Please ask for: Mrs D Johnson
Email: daun.johnson@arun.gov.uk
Telephone: 01903 737762
Our Ref: LU/136/21/PL
Your Ref:
Date: 30th April 2021

Application for Planning Permission

Development: Extension to Residential Care Home. This application may affect the setting of listed building, affects the character & appearance of the East Street Conservation Area & is in CIL Zone 4 (Zero Rated) as other development.
Location: Mewsbrook House 59 East Street Littlehampton BN17 6AU

DRAWING TITLE: EXISTING FIRST FLOOR PLAN

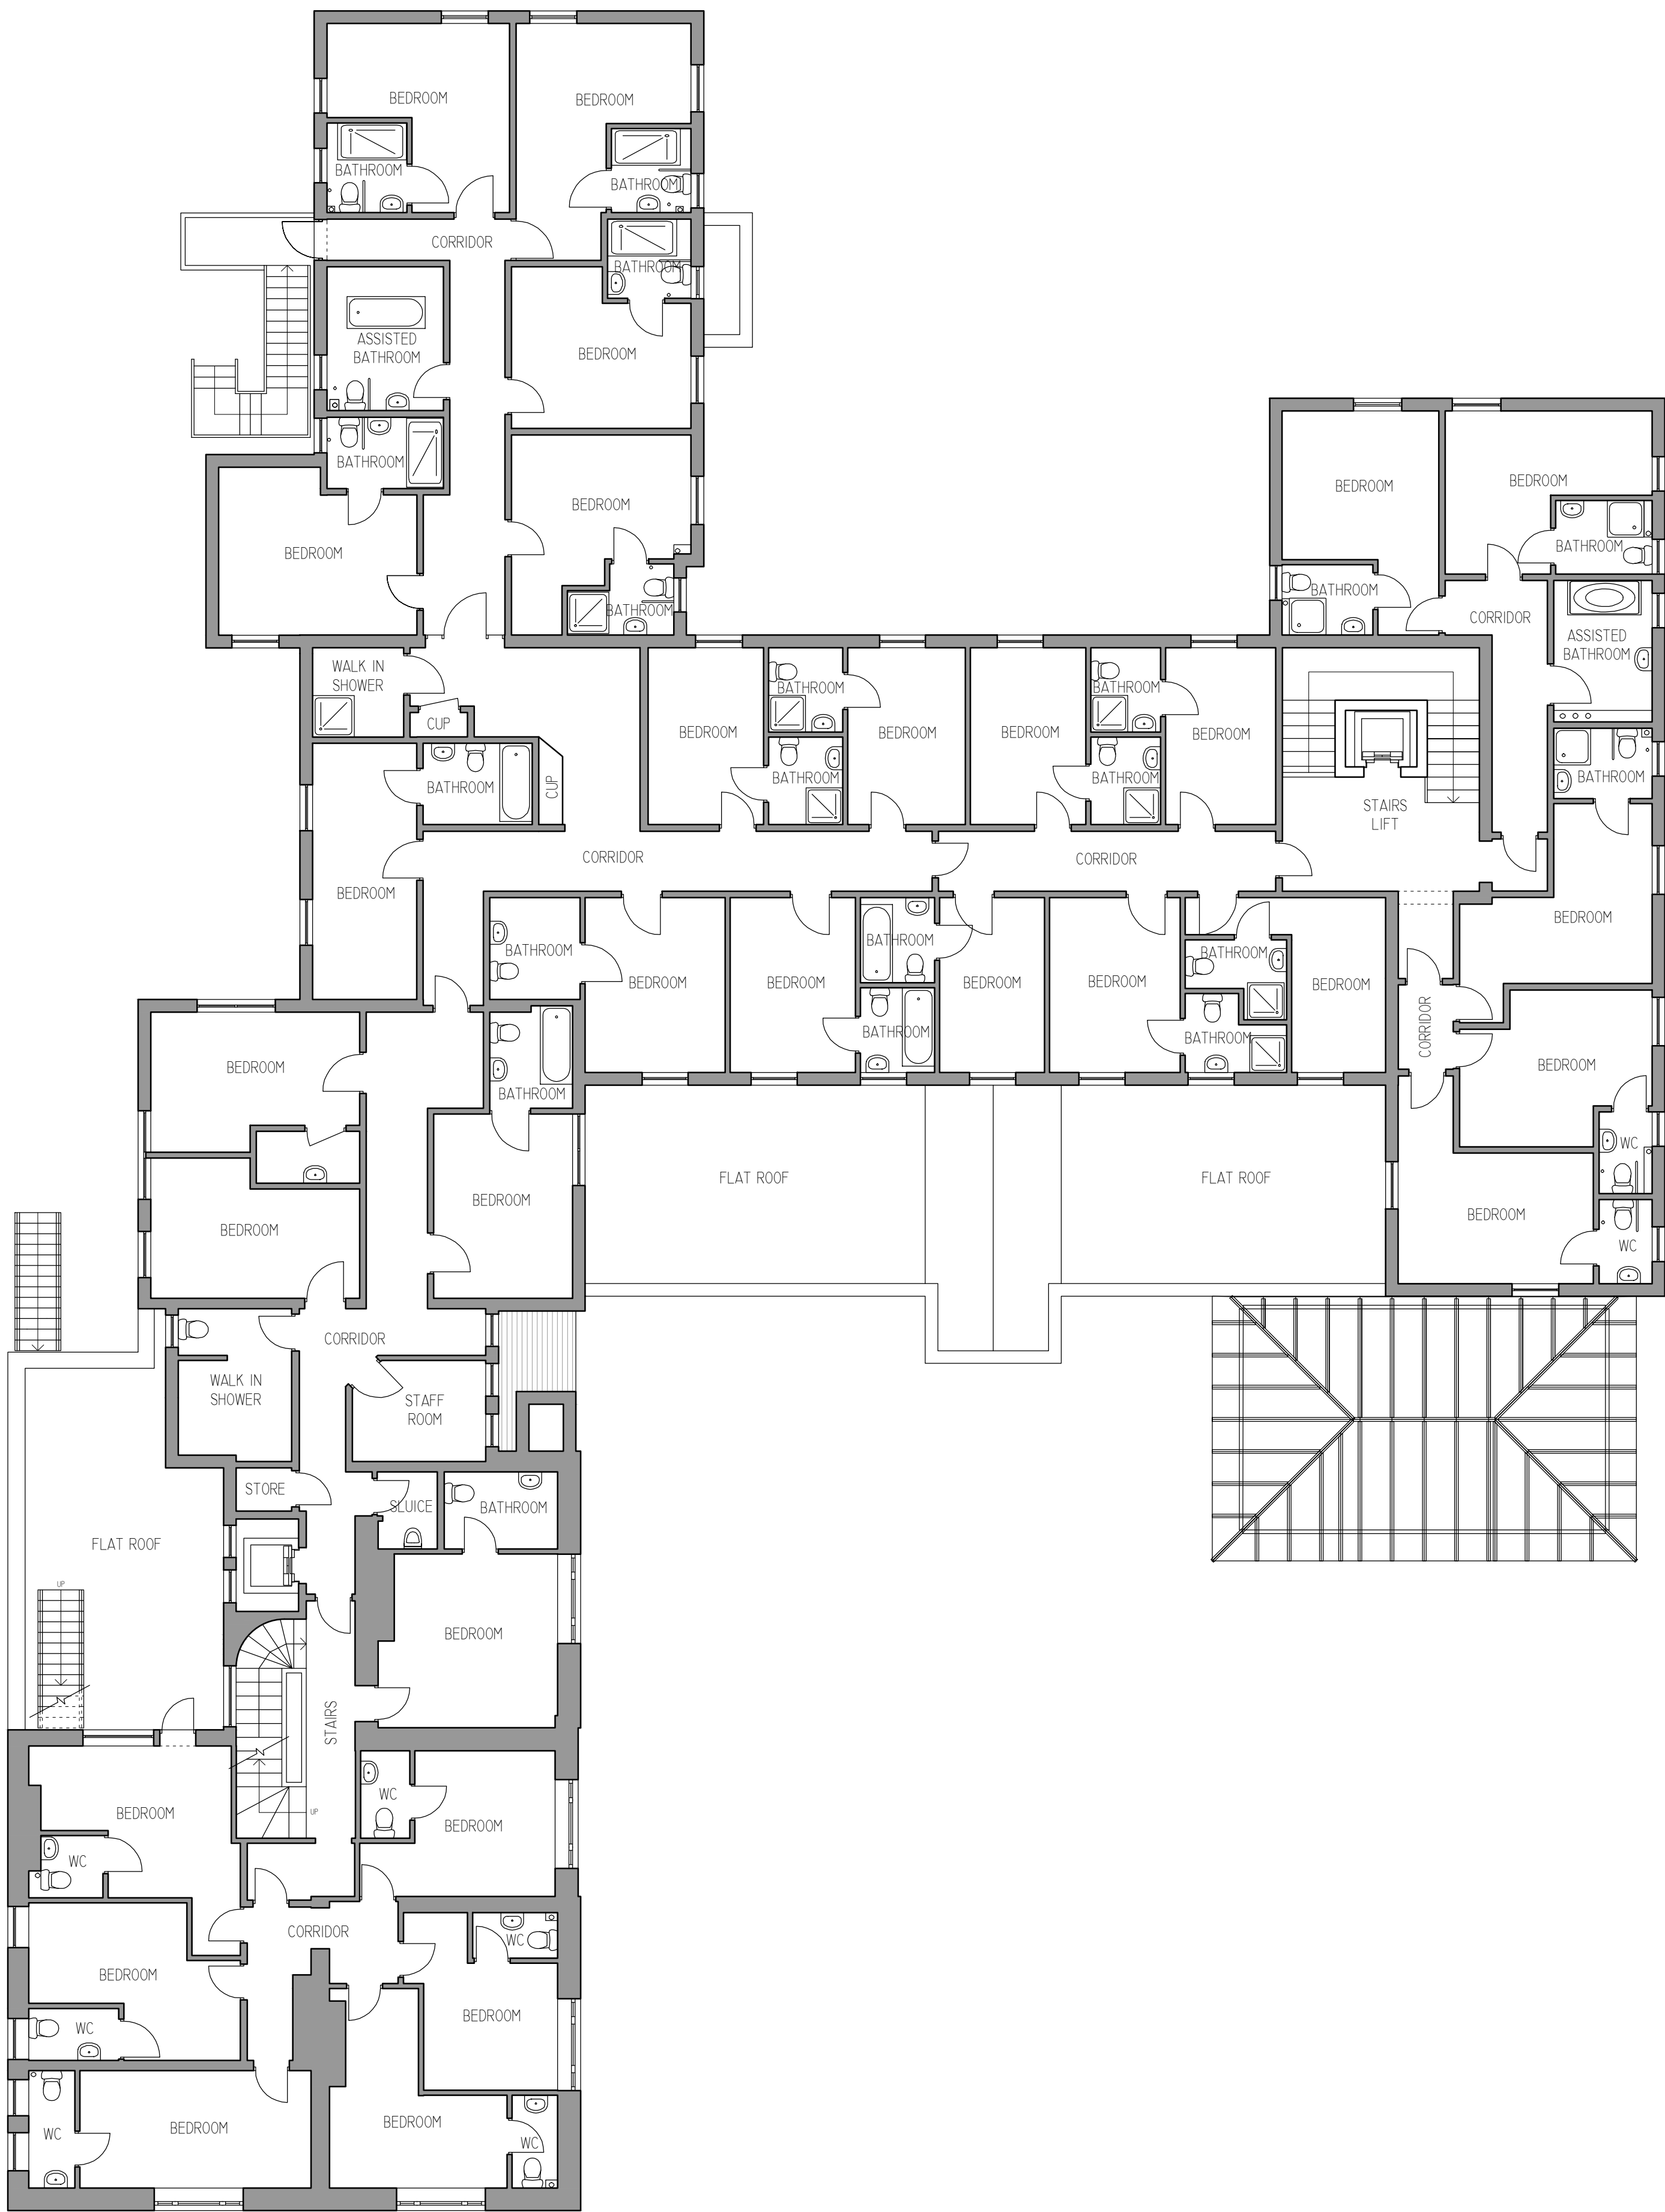
The existing and proposed West elevation B and first floor plan do not accord. Please amend accordingly.

The existing and proposed West elevation A and first floor do not accord. Please amend accordingly.

DRAWING TITLE
PROPOSED GROUND FLOOR PLAN

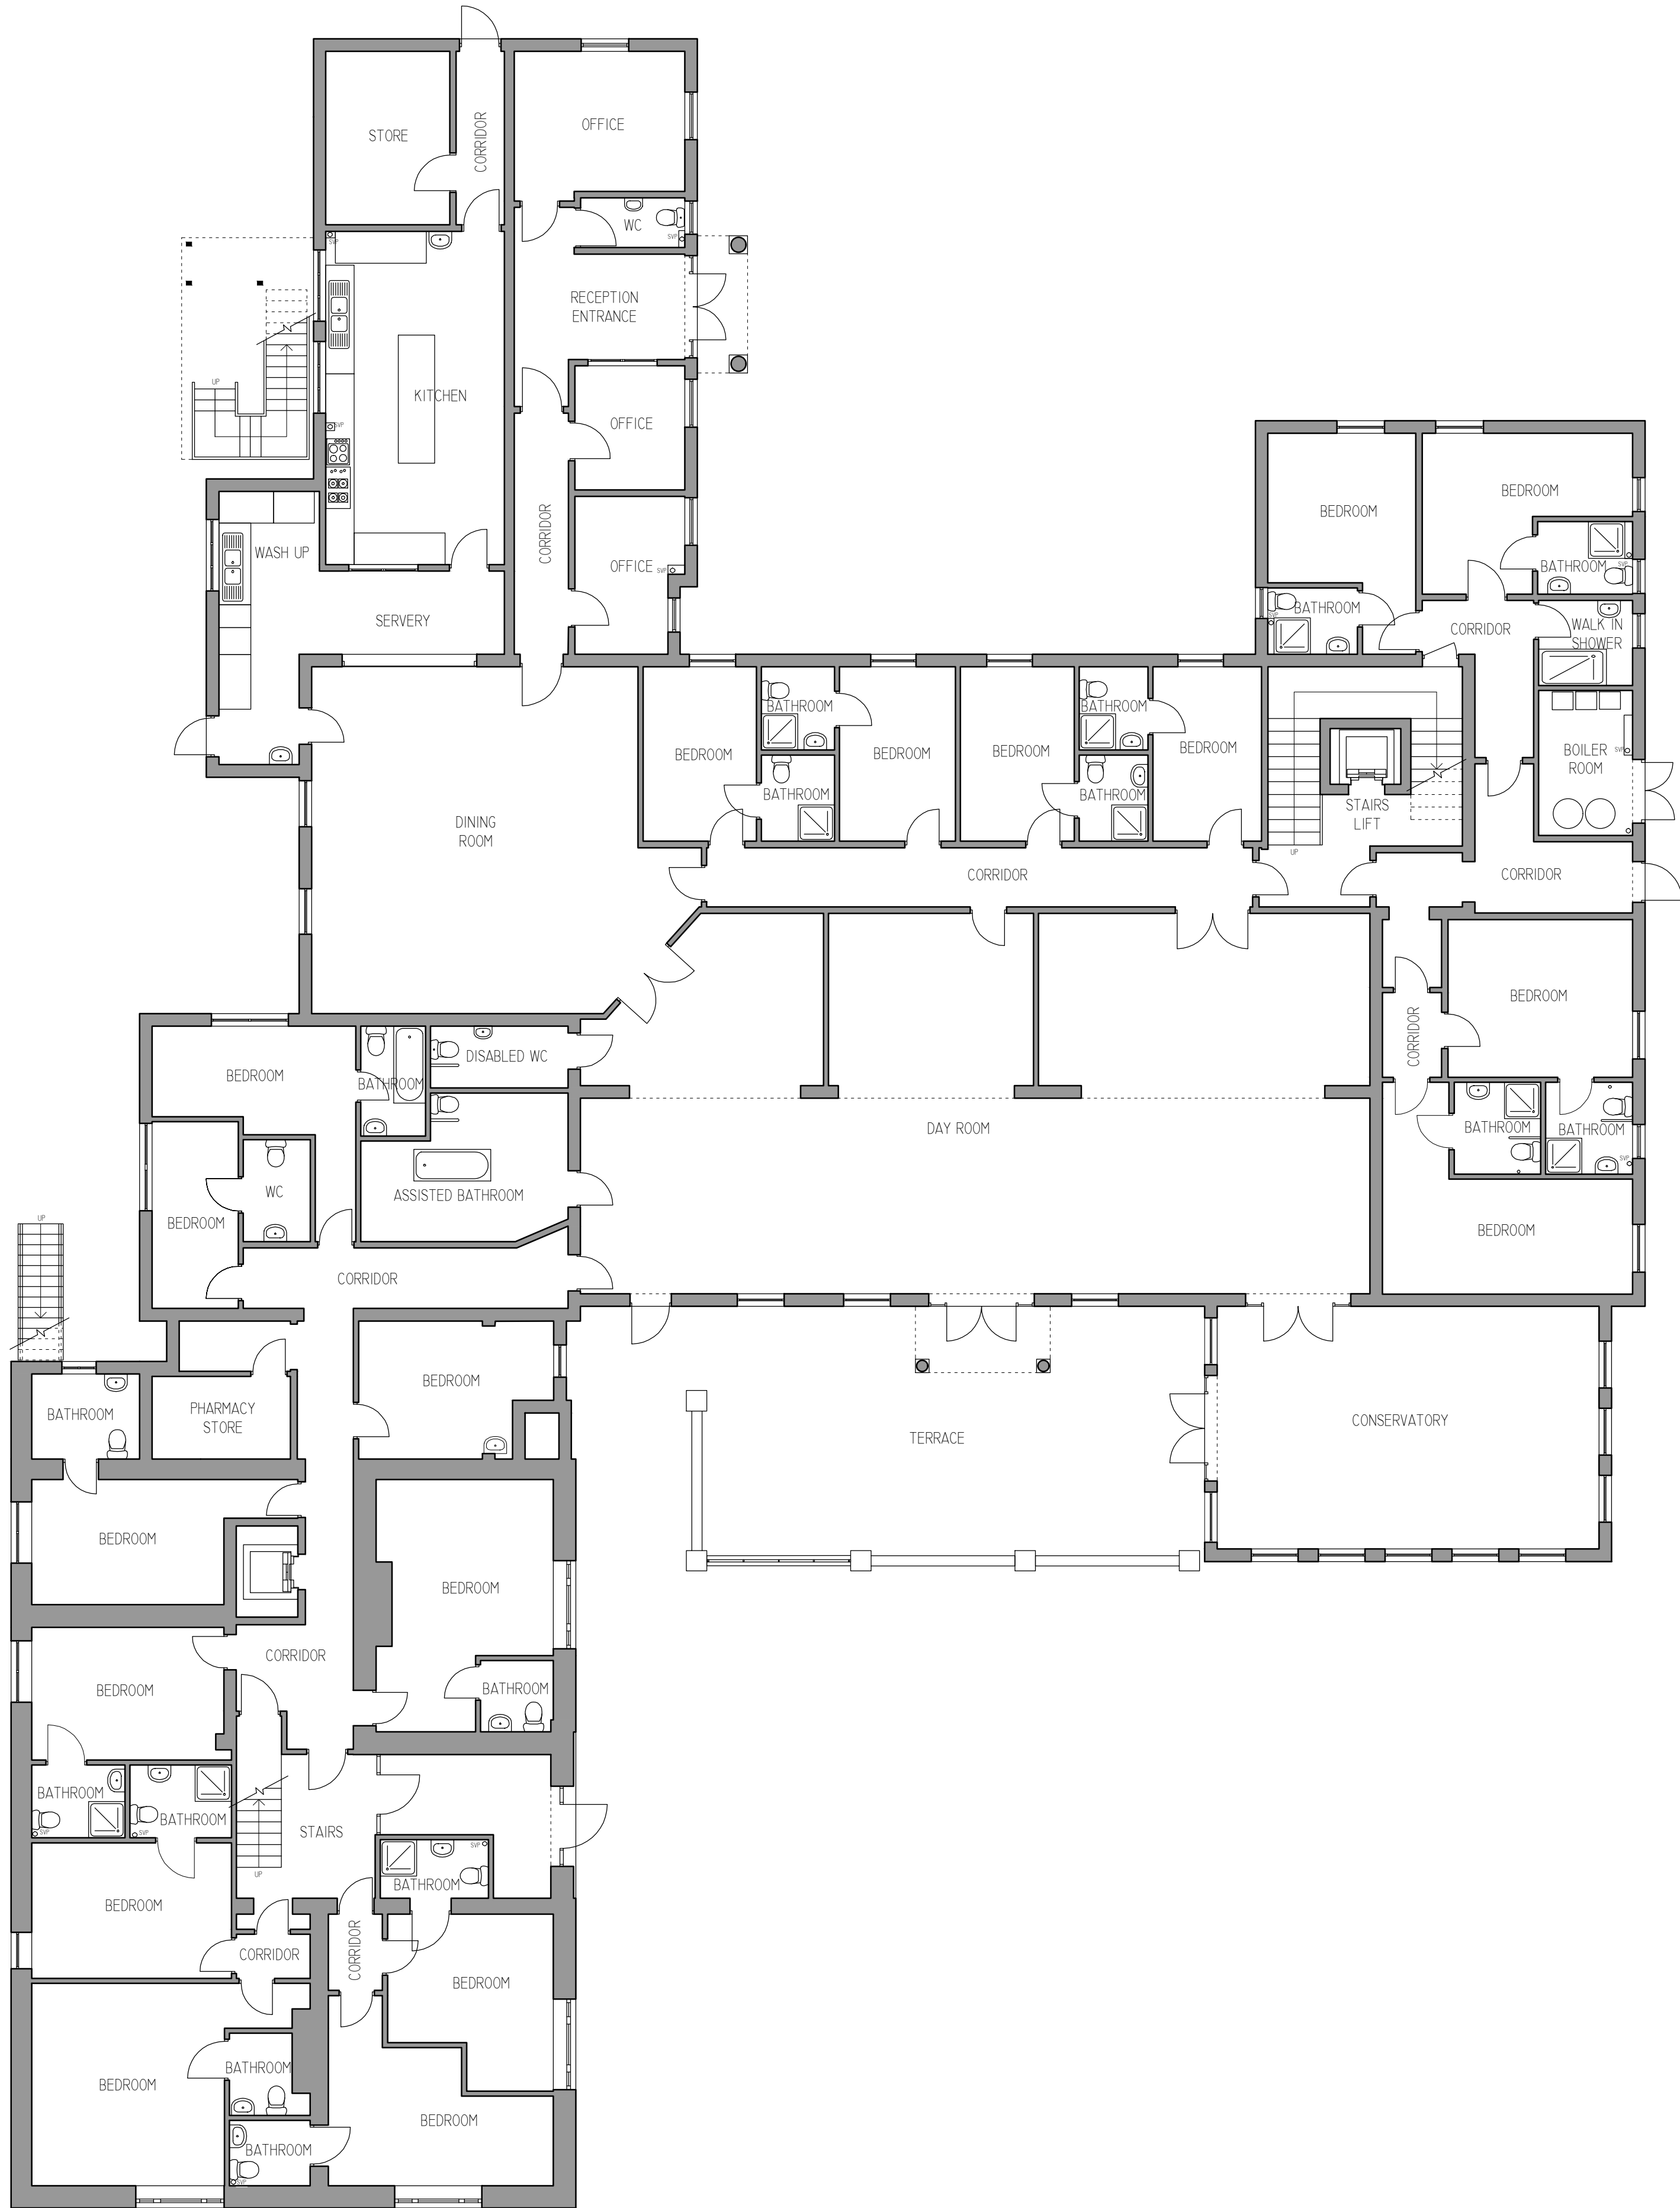
The existing and proposed East elevation and ground floor plan do not accord. Please amend accordingly.

the existing and proposed South elevation and ground floor plan do not accord. Please amend accordingly.

The existing and proposed West elevation A and ground floor plan do not accord. Please amend accordingly.

DRAWN BY: EL
DATE: 3RD JUN 2021
DRAWING TITLE: EXISTING SECOND FLOOR PLAN
SCALE: 1:100 @ A1
DRAWING NO: E106

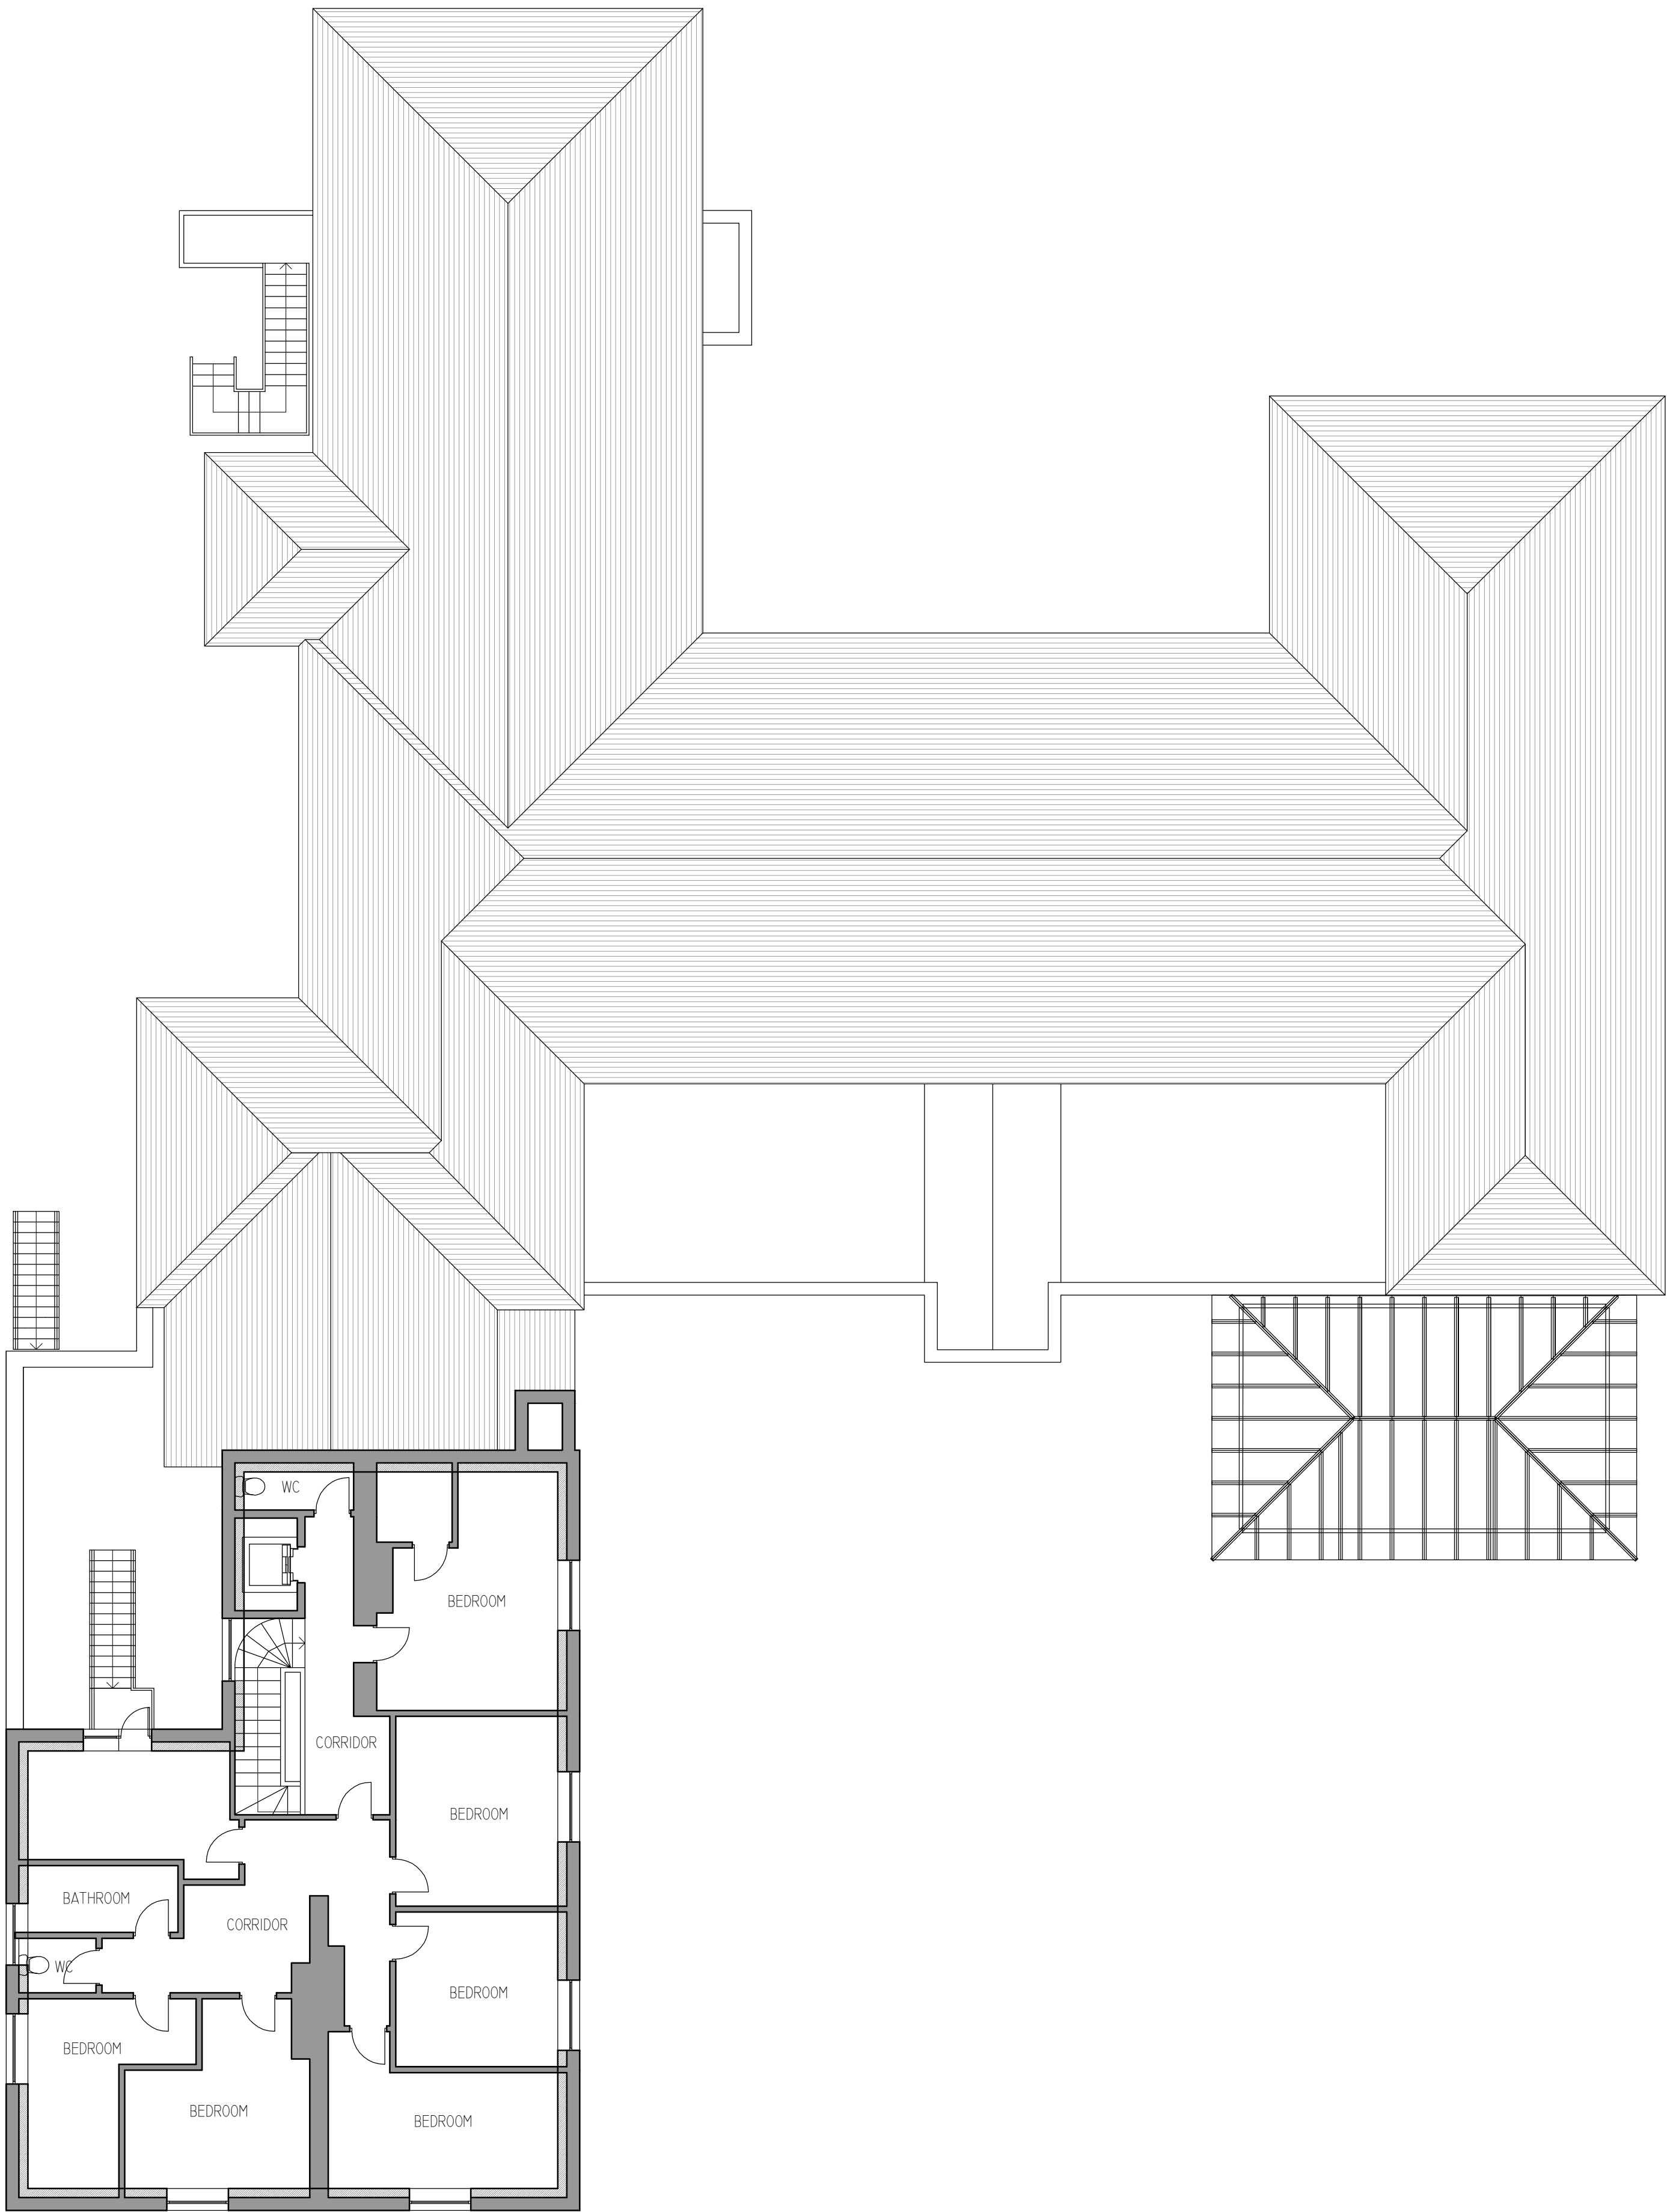
Please provide an existing second floor plan.
